Application no: 22/03693/DISC

Location: Land Adj To Promised Land Farm, Wendlebury Road, Chesterton

Lead Local Flood Authority

Objection

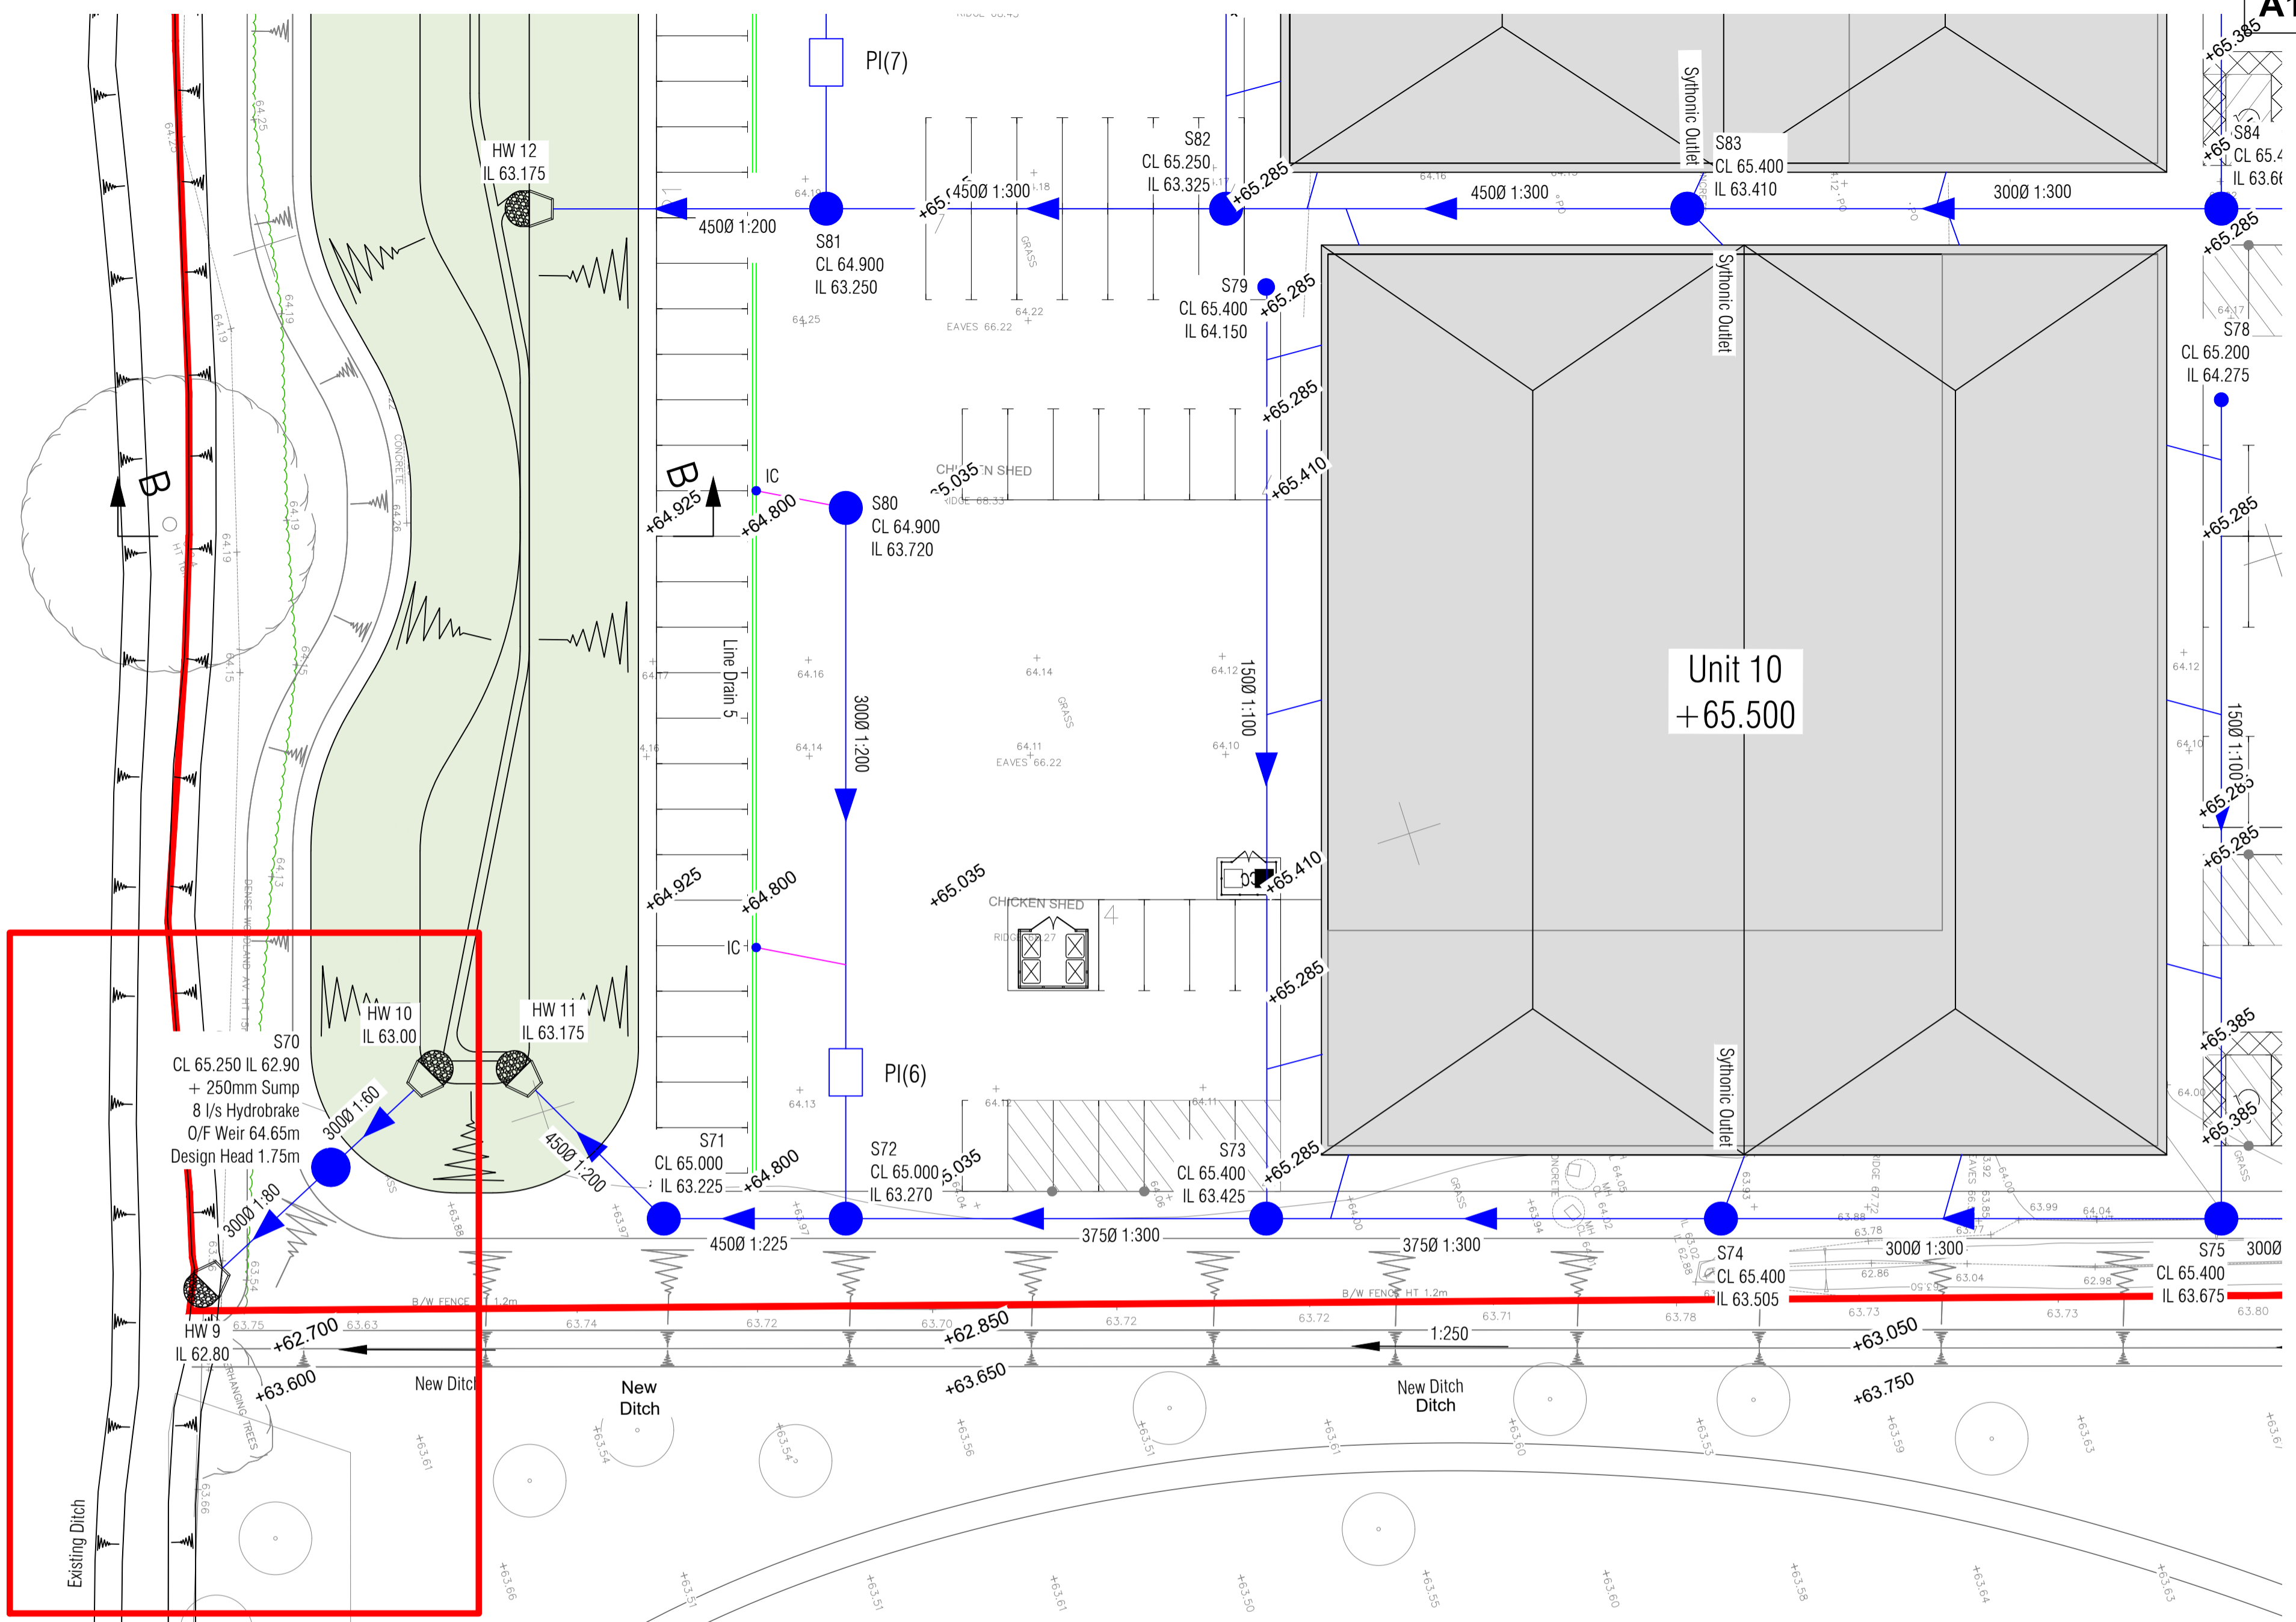
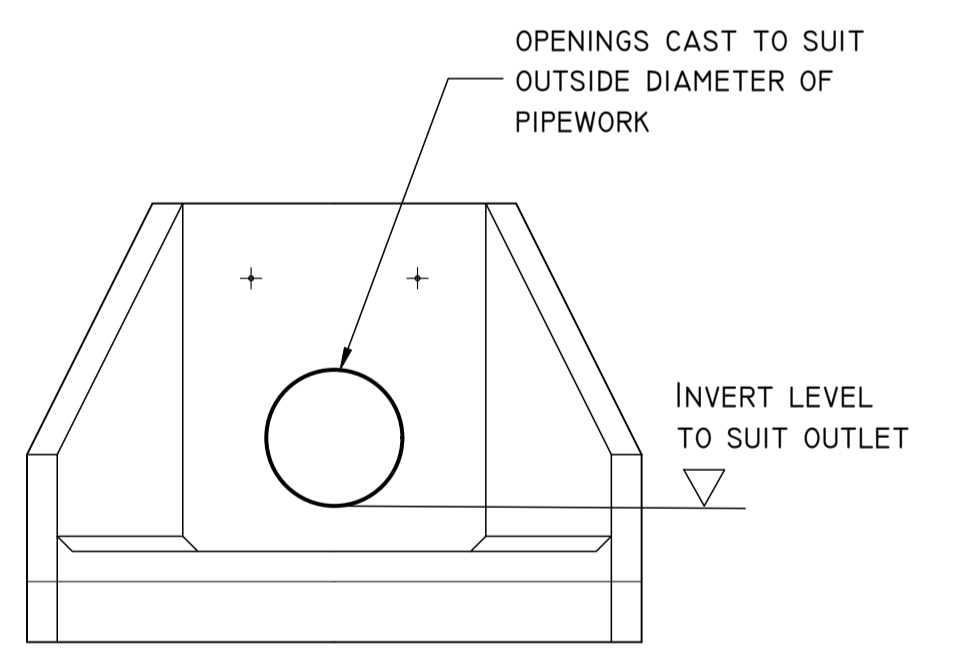
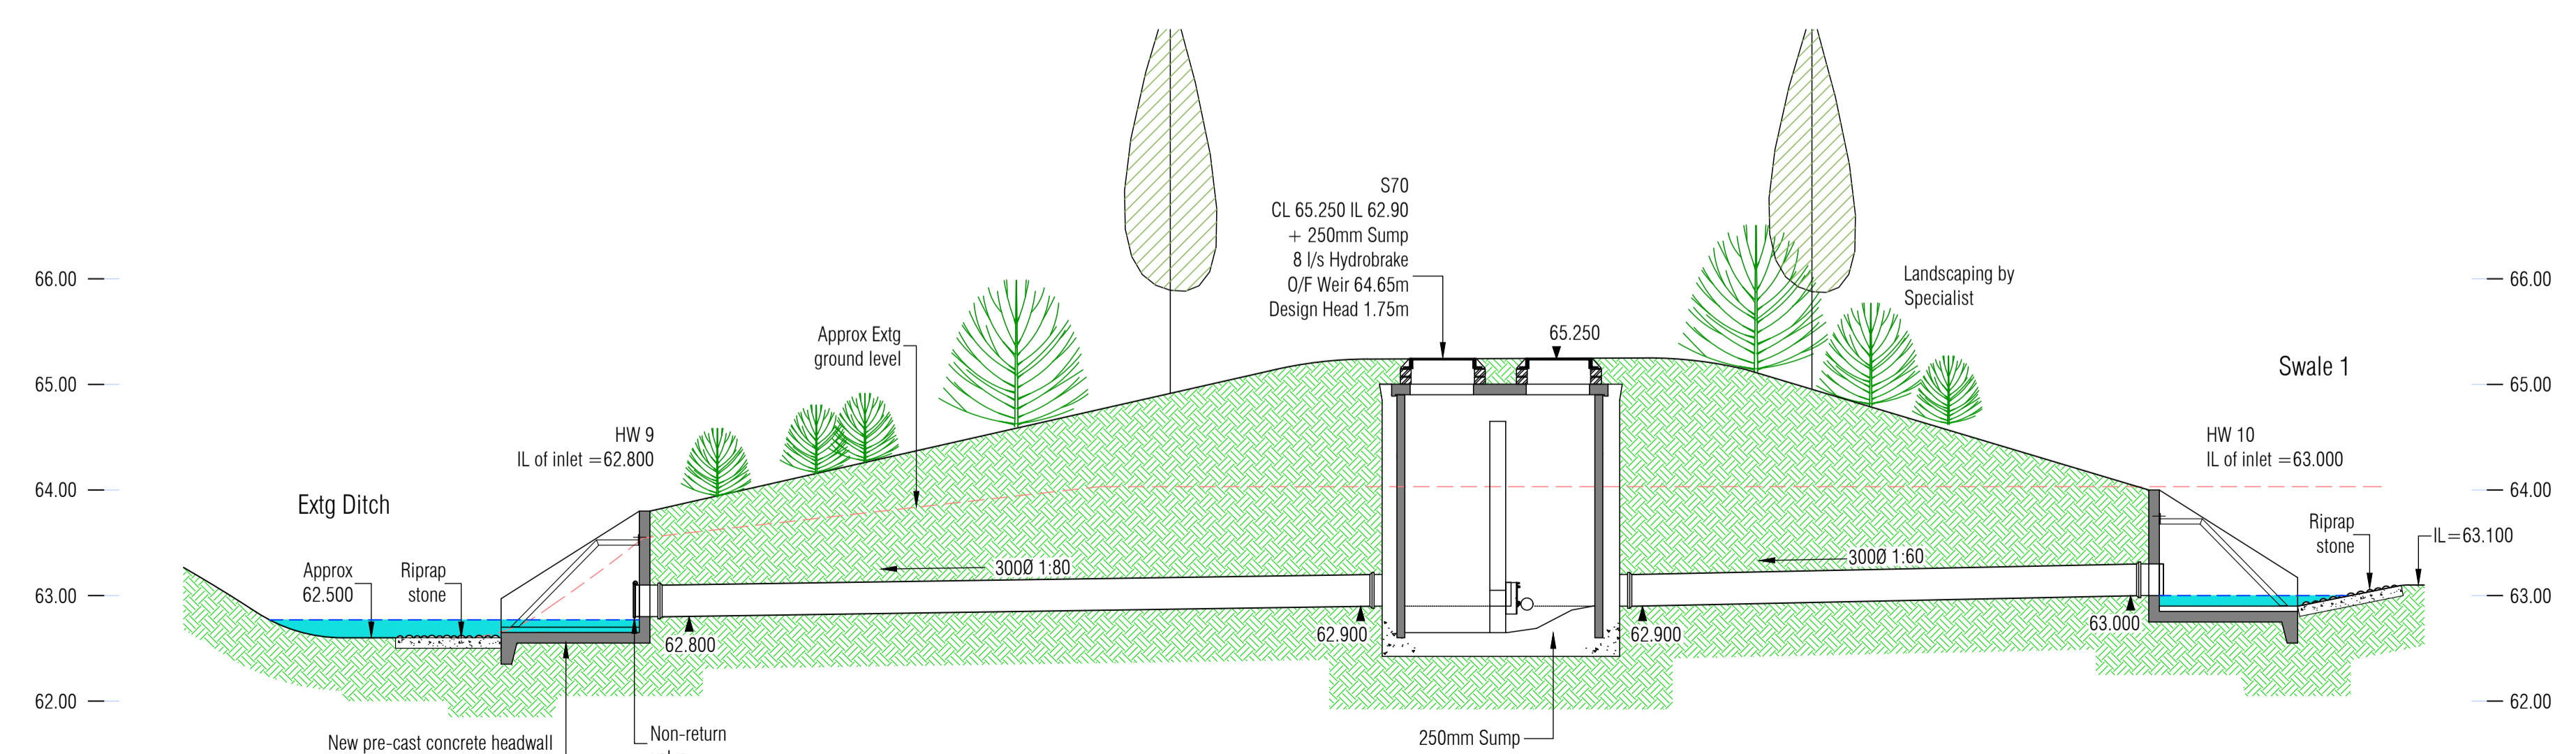
- Provide consent to discharge to the existing watercourse. Confirm the capacity of the ditch to take the proposed loads without posing flood risk to the neighbouring sites. EA consent to be provided.
